A585 Windy Harbour to Skippool Improvement Scheme

TR010035

7.11 Environmental Statement Changes and Corrections Document

May 2019

Status	DEADLINE 2 SUBMISSION	Revision	1
Scale	1:2500 A3	Date	MAY 2019
Drawn By	J.NORMAN		
Checked By	K.BURROWS		
Approved By	N.HENDERSON		
PINS No.	TR010035	FIGURE	11.4
Drawing number	HE548643-ARC-EGN-SZ_ZZ_000-DR-LE-30

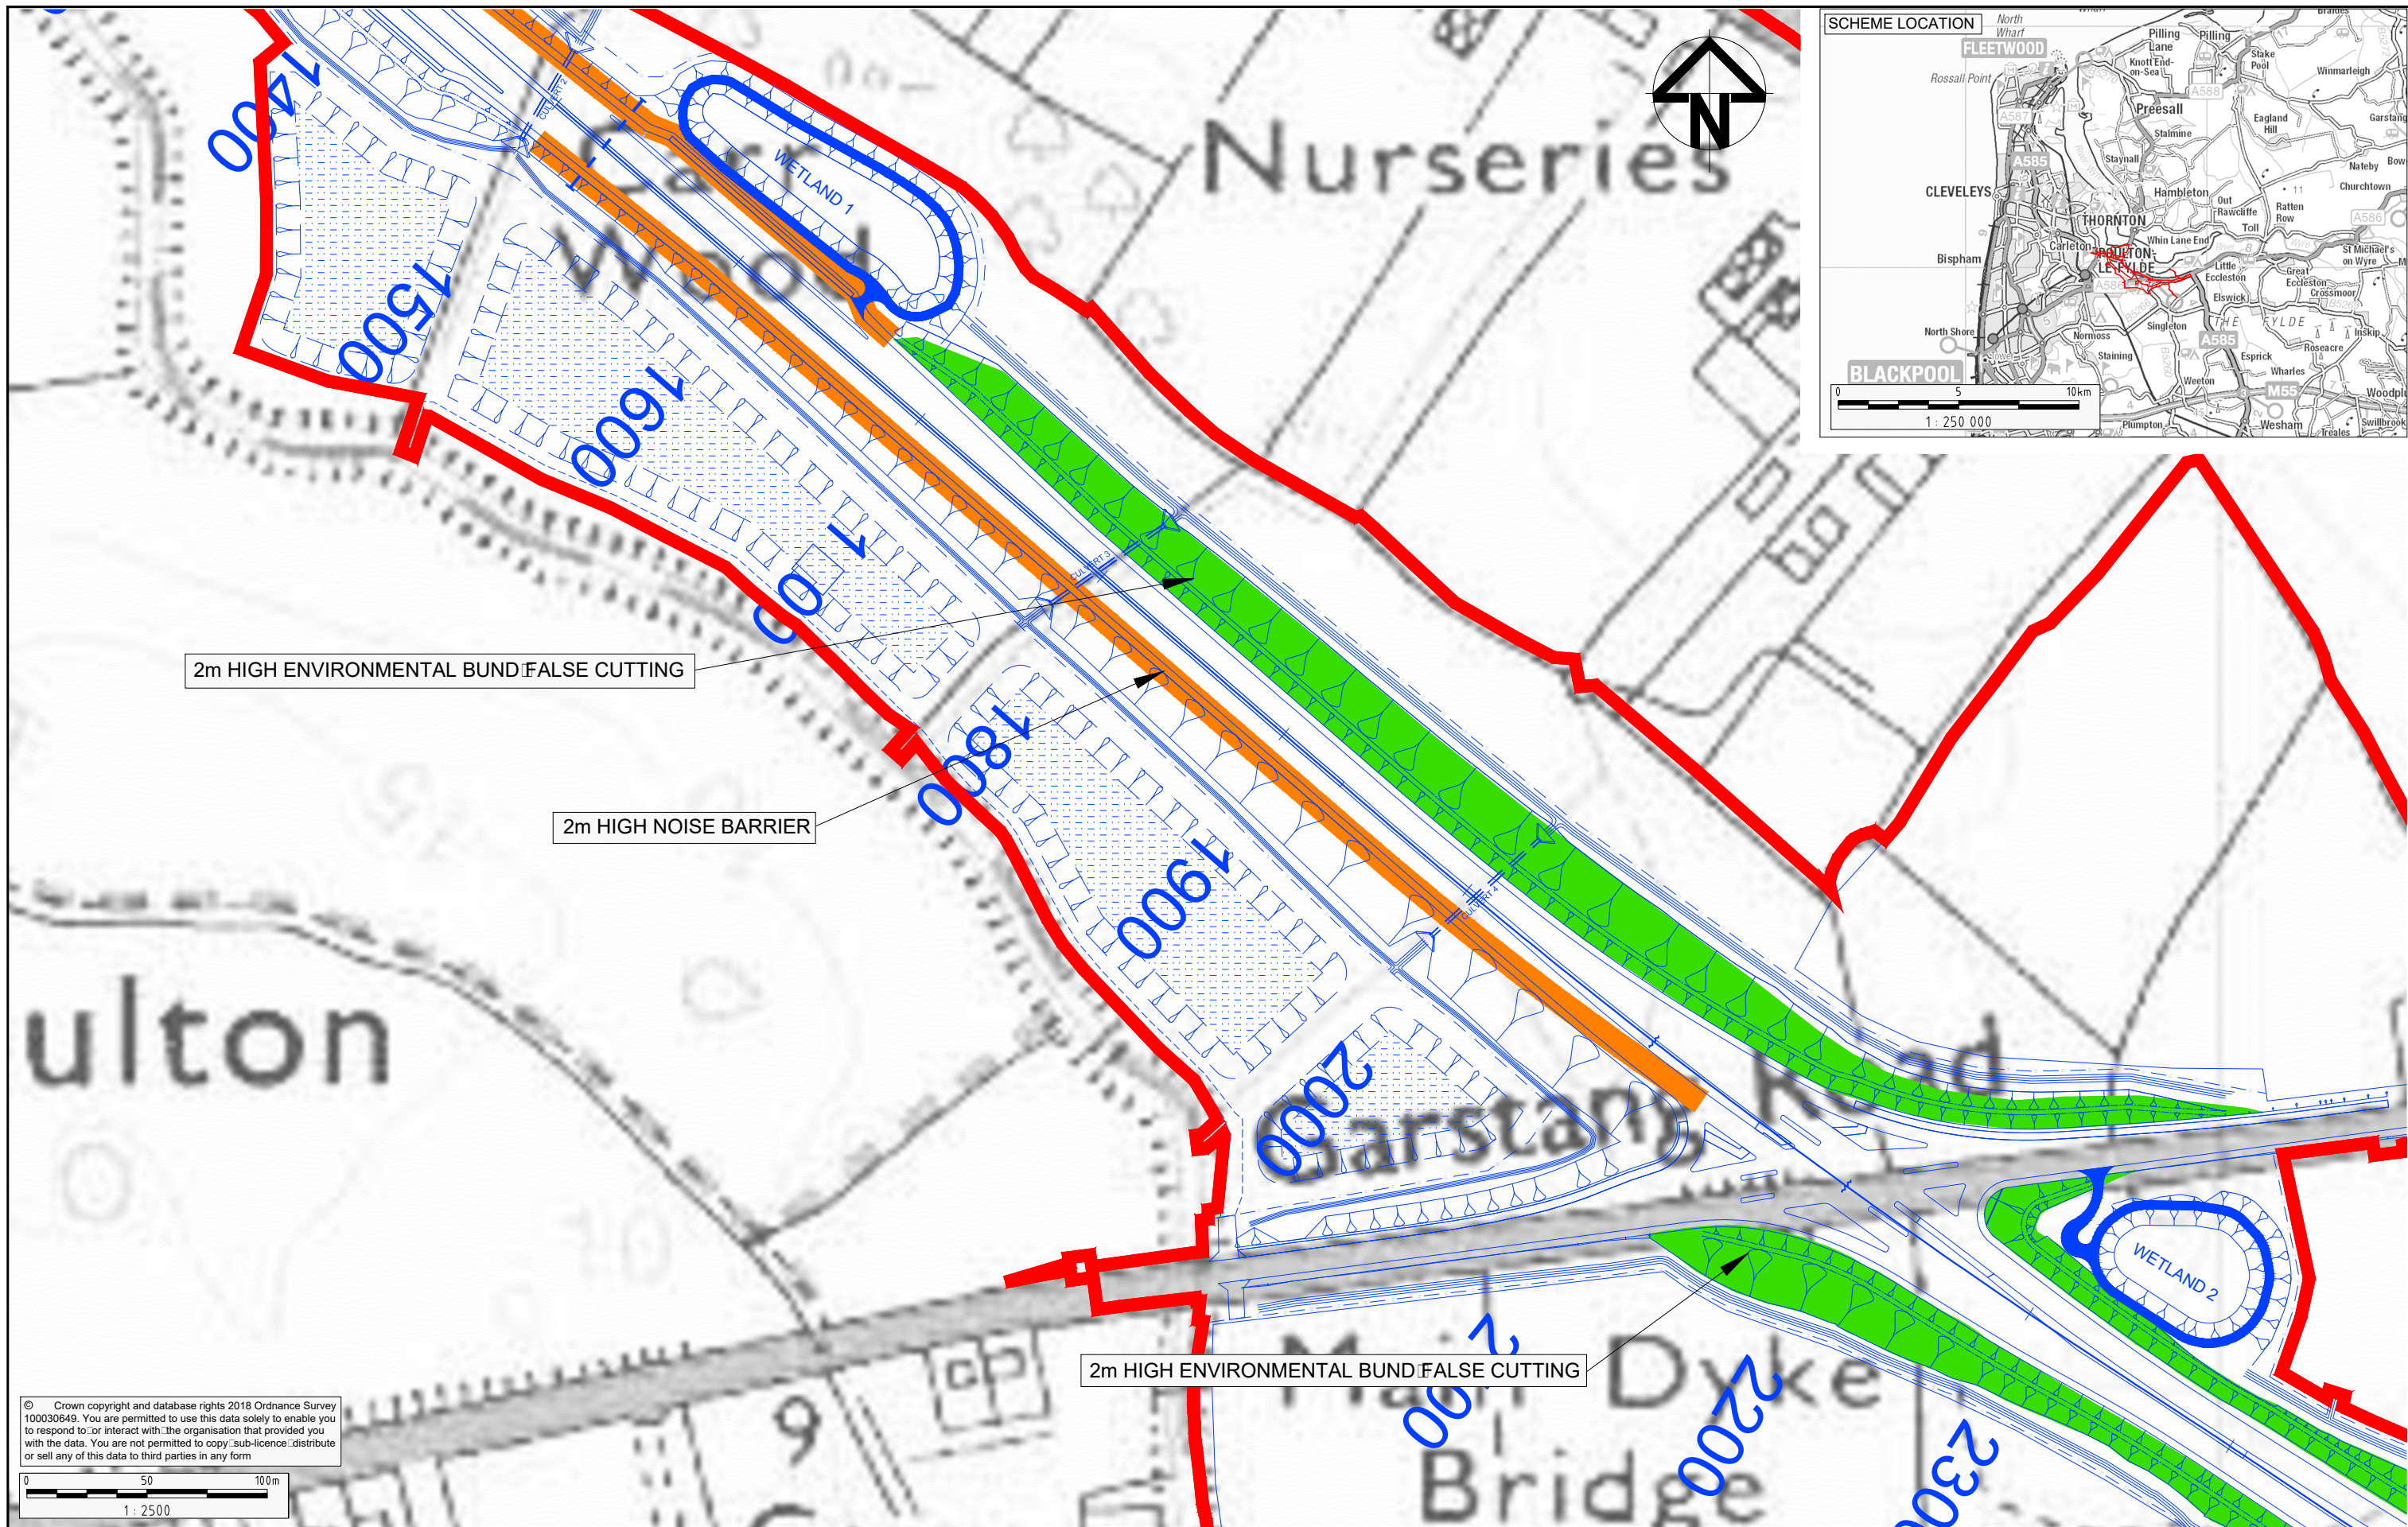
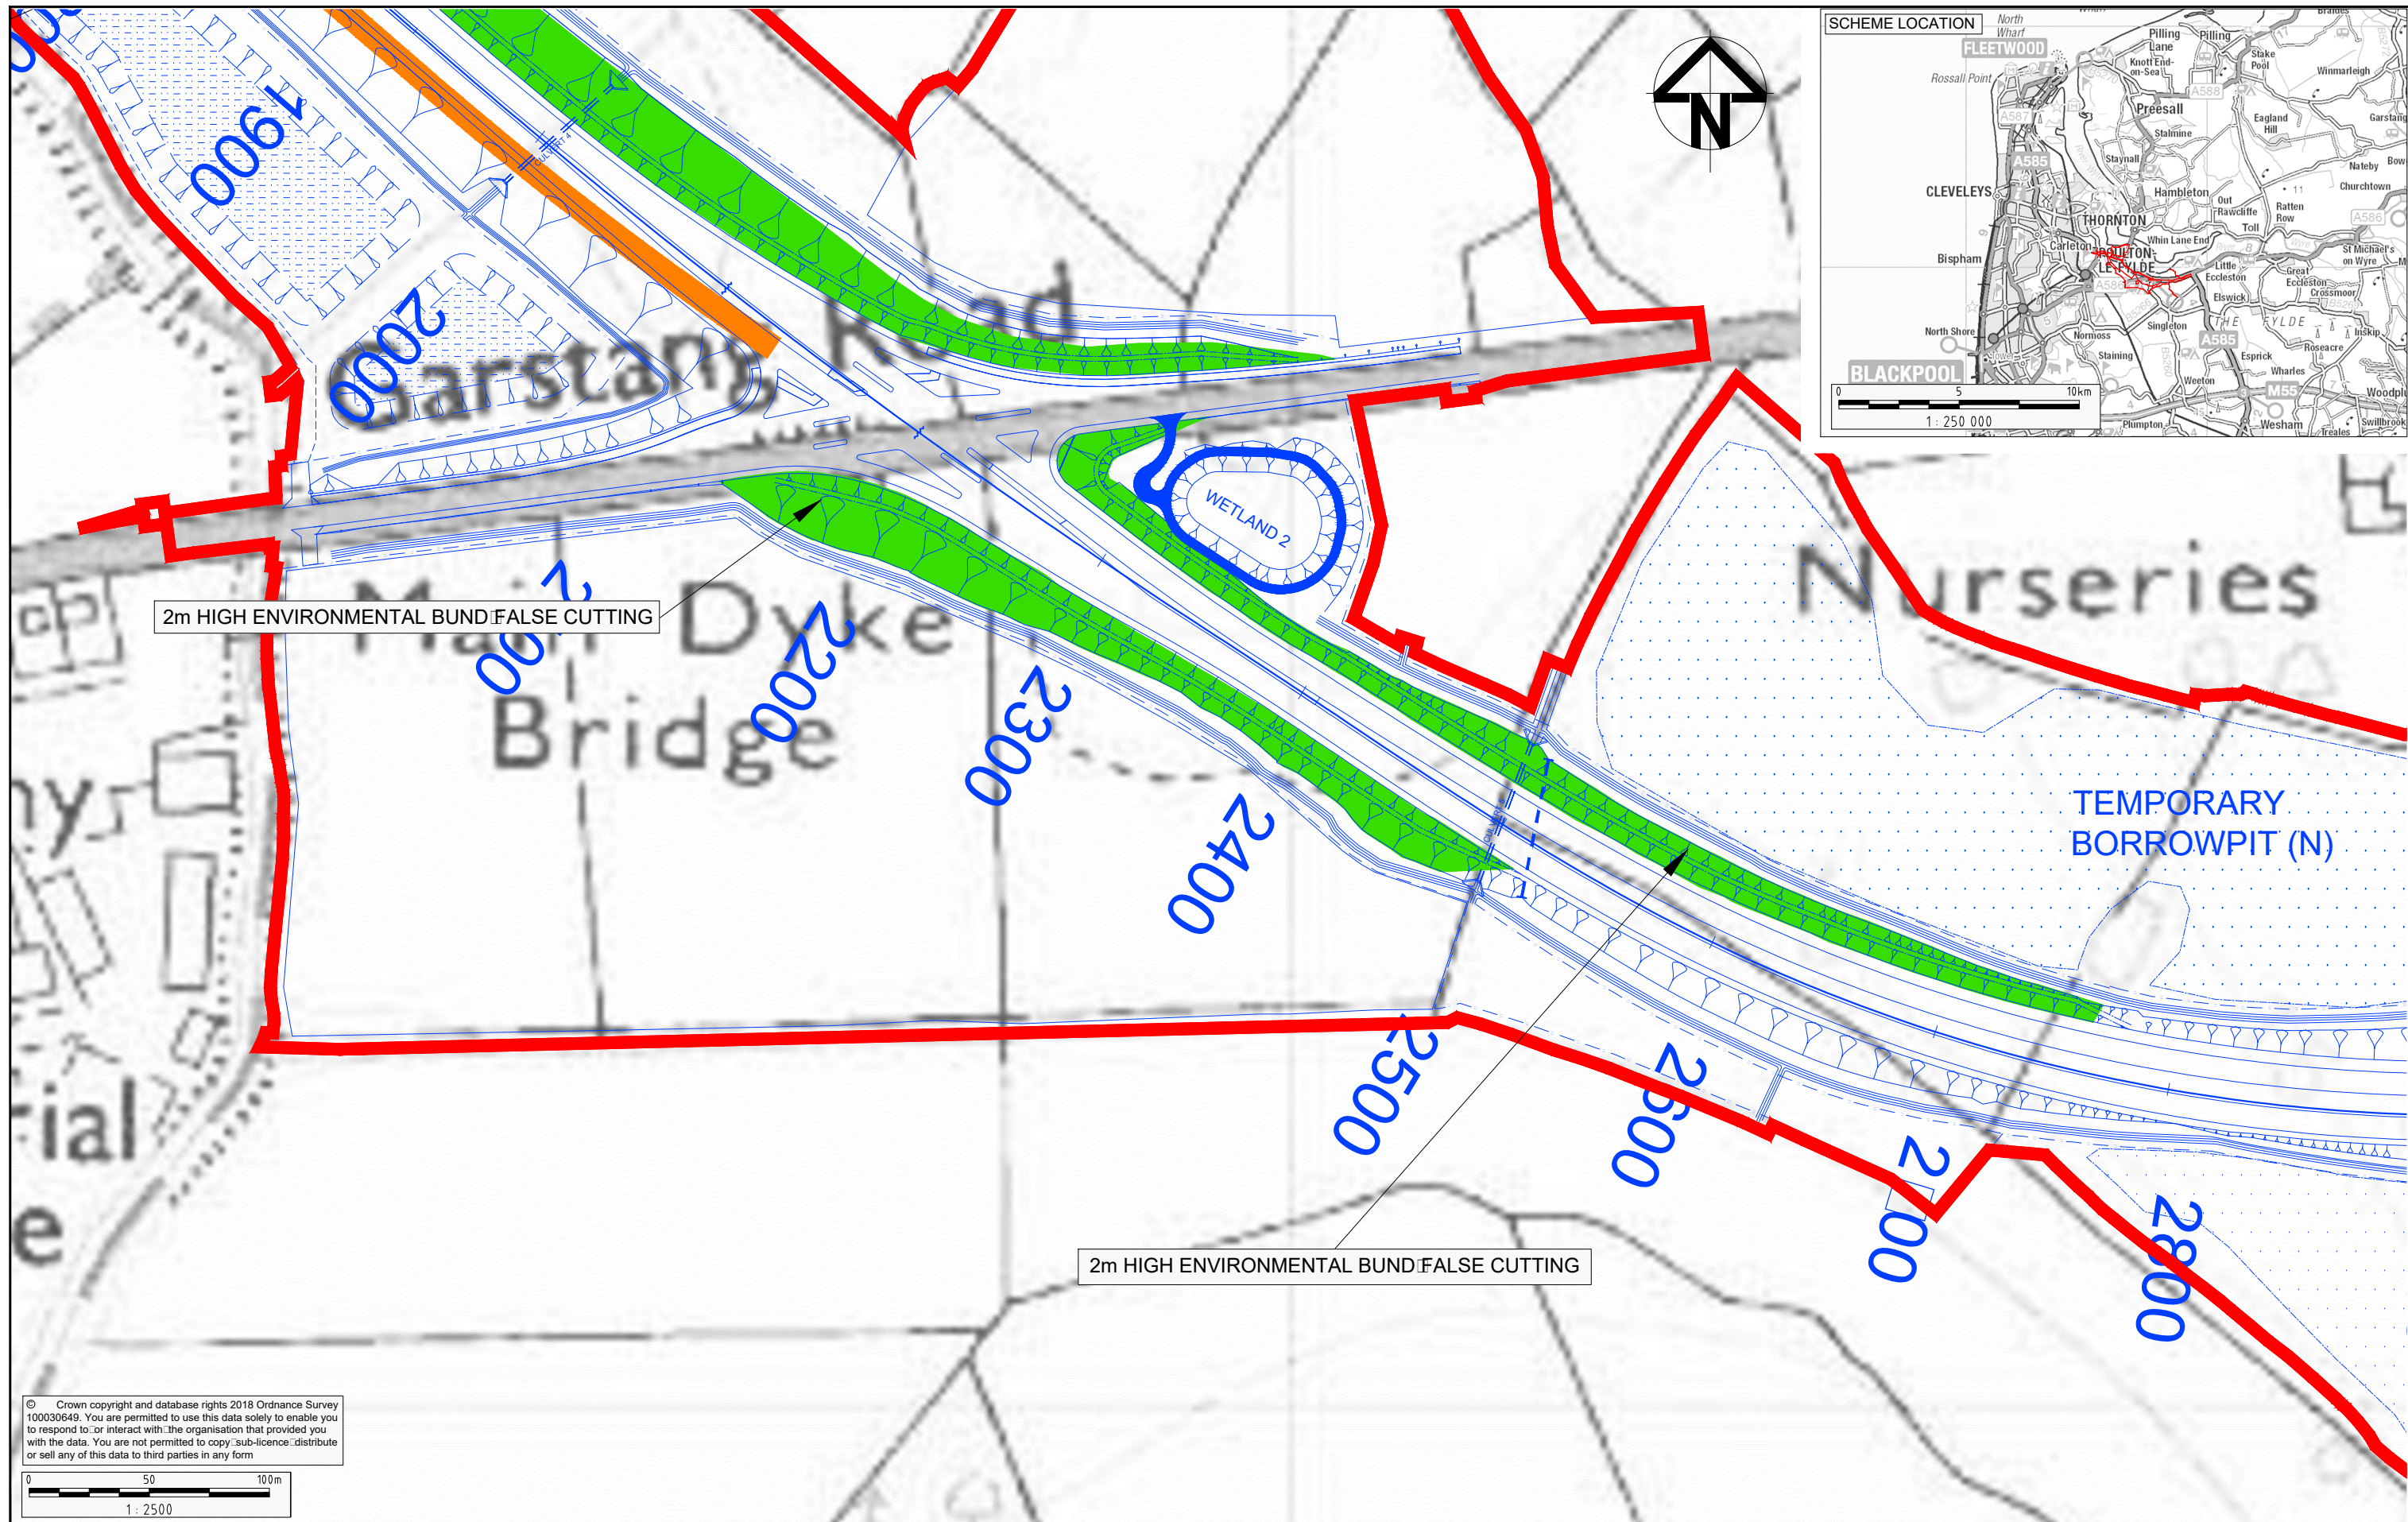
6.11	ES Chapter 11: Noise and Vibration	Update to Figure 11.4: Noise and Vibration – Noise Mitigation within the Study Area presented at Appendix D to show heights and locations of earth mounds and acoustic fencing at a larger scale.	Requested by the Inspector within the first round of written questions (document reference TR010035/APP/7.10).
